From: Patrick Barry [REDACTED]
Sent: 01 September 2020 12:47
To: Simon Davis <Simon.Davis@arun.gov.uk>
Subject: BN/39/20/PL

Further to our discussion on Friday afternoon, I have set out below responses to residual queries.

Figure 7: Swept Path Assessment

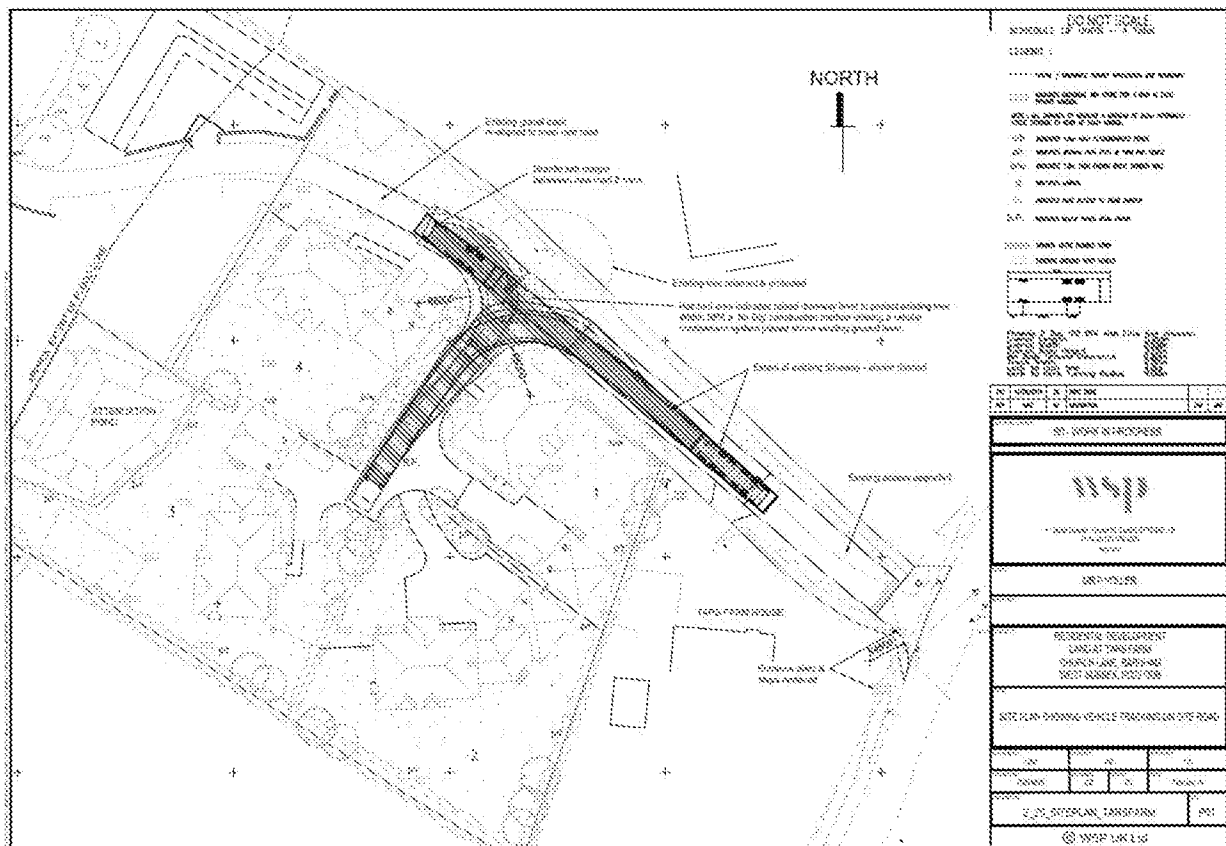
Refuse and Emergency Services Vehicle Access – Please find attached a tracking plan of the access as recently agreed with the HA. This is tracked for a refuse vehicle as per the submitted TA (11.2m). There are no conflicts and the refuse vehicle is larger than emergency services vehicle.
